RE: SSI 6878 - Albion Park Rail Bypass Project (RMS)

Please find enclosed a submission on the RMS Albion Park Rail Bypass Project on behalf of Holcim (Australia) Pty Ltd (Holcim Australia). The EIS supporting the Project application has been on public exhibition, with the period concluding Friday 27 November 2015.

# Map 3 - Southern Interchange

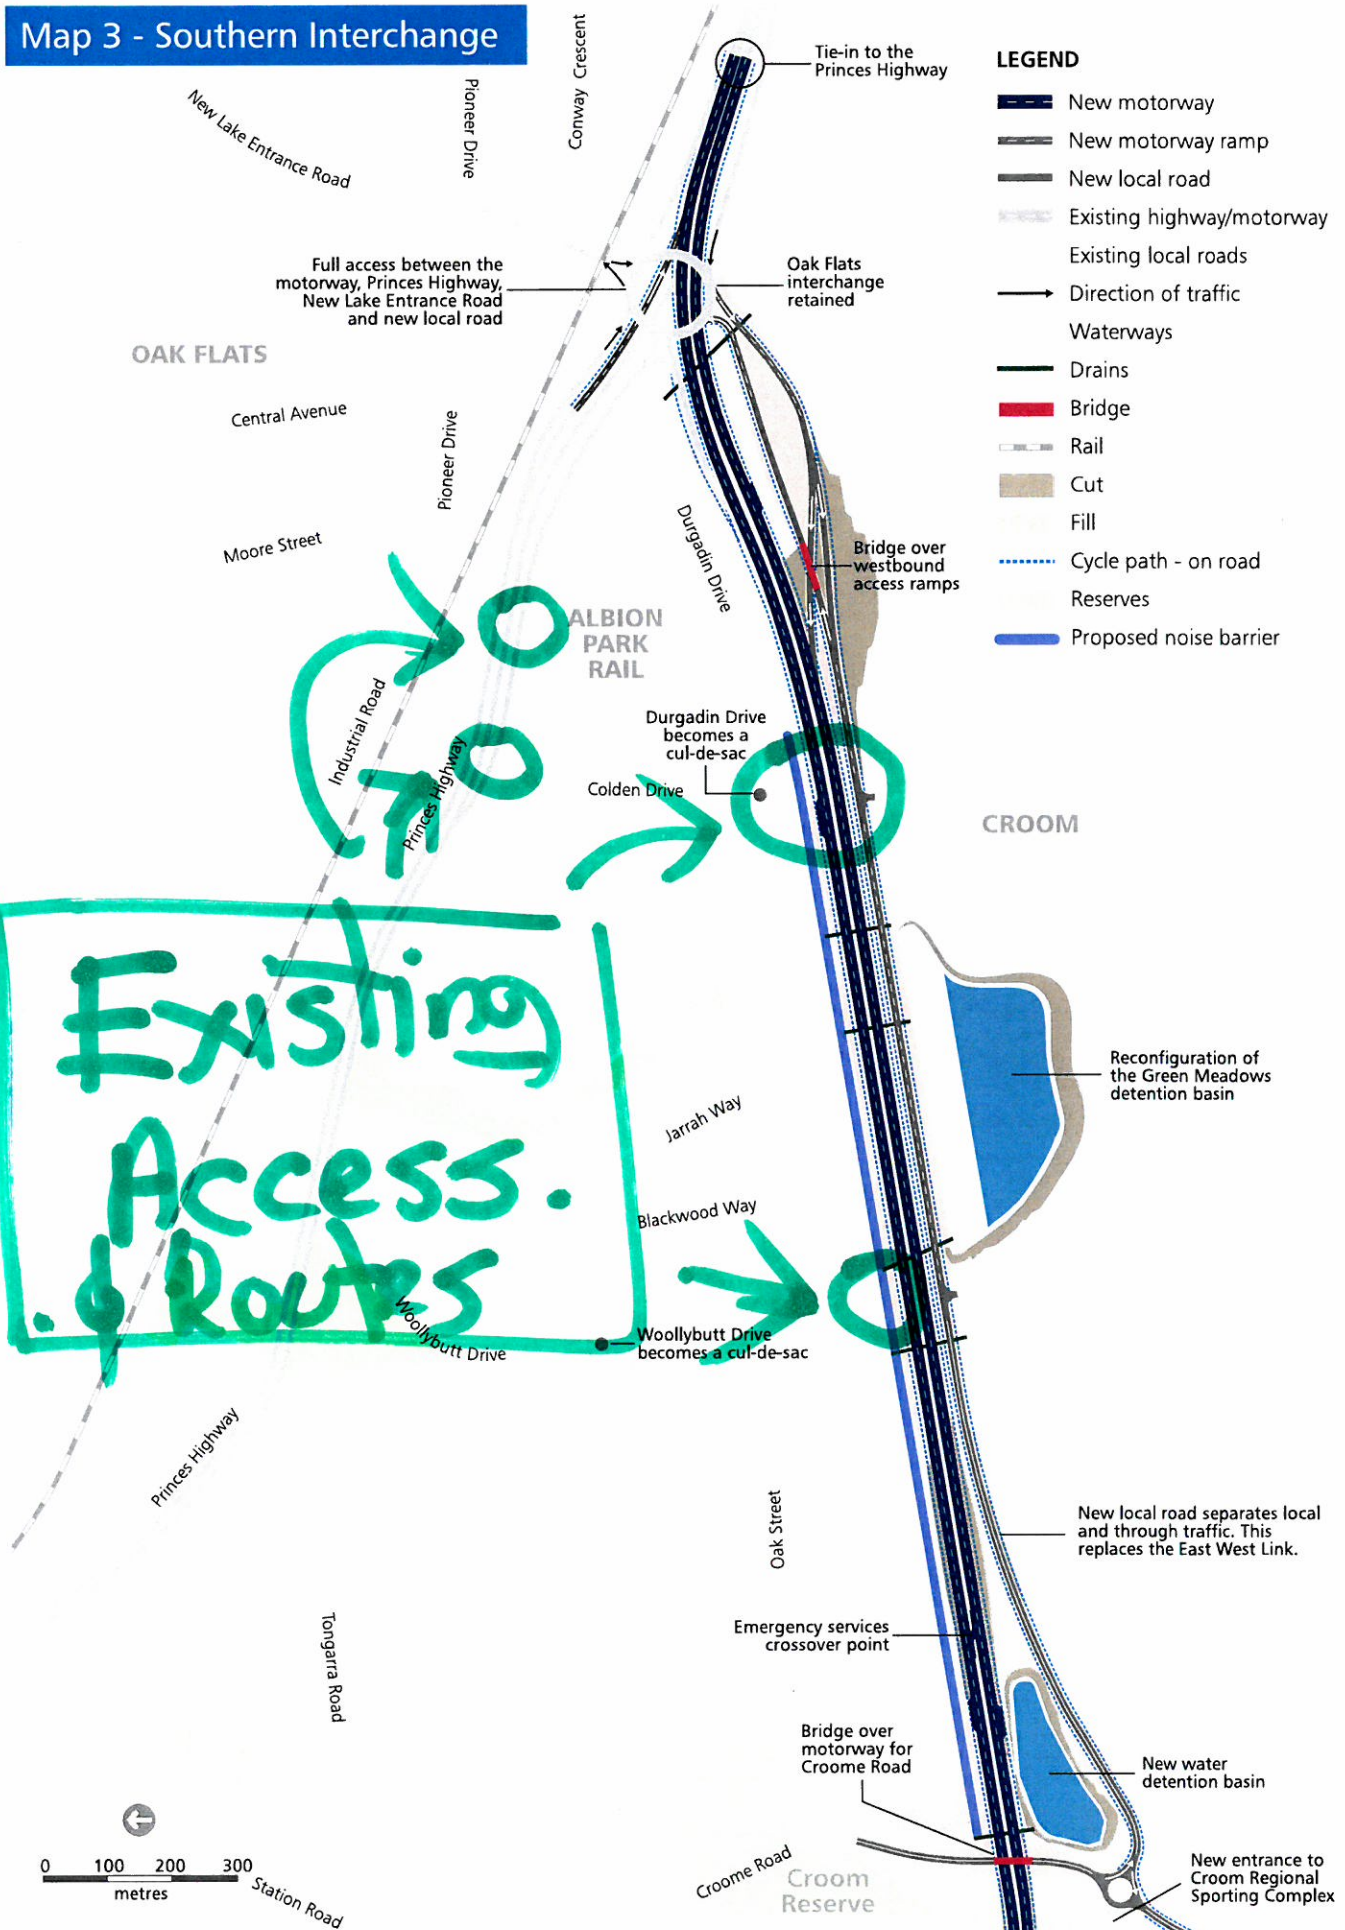
The existing East West Link is proposed to be removed and replaced by a new road about 25 metres to the south of the bypass motorway to become the new (proposed) East West Link. The new road would have one lane in each direction. A new intersection is proposed to provide an access point for the Holcim site. The proposed intersection layout for both quarry access points would consist of channelized right turn with 110 metre turning lane and an auxiliary left turn with deceleration lane of 50 metres. The existing round-a-bout is proposed to be replaced with a T intersection, controlled by signage. It could not be determined if pedestrian and/or cycle paths were detailed in the proposal.

Holcim believes that the proposed T intersection does not give adequate consideration to the integration of site traffic (quarry and concrete) with future road use. Movements to and from the site have been severely under-estimated (114 V 780), thus bringing in to question the ability of the proposed intersection to cater for site traffic. In addition, no data could be found on required lead times for fully-laden heavy vehicles merging with other vehicles. An acceleration lane has not been mentioned. Holcim is concerned that heavy vehicles exiting the site would encounter substantial waiting times before departing the T intersection and merging with other road users.

Movements from the site (ie - laden heavy vehicles) during peak hours would be severely impacted by the T intersection proposal. It is anticipated that wait times would be substantial. Holcim is concerned about the flow-on effect this would have to site operations - effectively 'banking' vehicles up before they could exit the site. Given the proposed East West route would consume roughly 25 metres of existing buffer between the site weighbridge and the existing round-a-bout, ability for trucks to queue prior to departure would be removed.

The location of the proposed East West route would jeopardise the functionality of the site weighbridge. By removing ability for trucks to queue (following ticketing) prior to departure, the use of the weighbridge would effectively be controlled by the ability for heavy vehicles to depart the site in a timely manner. Holcim does not consider this to be an acceptable impact from the Project.

The Holcim Albion Park site is a regionally significant resource and must be protected. The inadequate design of the proposed intersection (between the site and East West Link replacement) to cater for site movements, leading to lengthy wait times for exiting vehicles, seriously jeopardises the operation of the Holcim site. Holcim does not consider the proposed changes to be acceptable to their operations and objects to the Project proposal, in it's current form. Current access arrangements for the site (ie - round-a-bout) should not be jeopardised by the Project. Any impacts to functionality of operations must also be mitigated, ie - relocation of site weighbridge to allow for continued operations.

Additionally, no pedestrian or cycle paths should be located along the same side of the road network as the Holcim site.
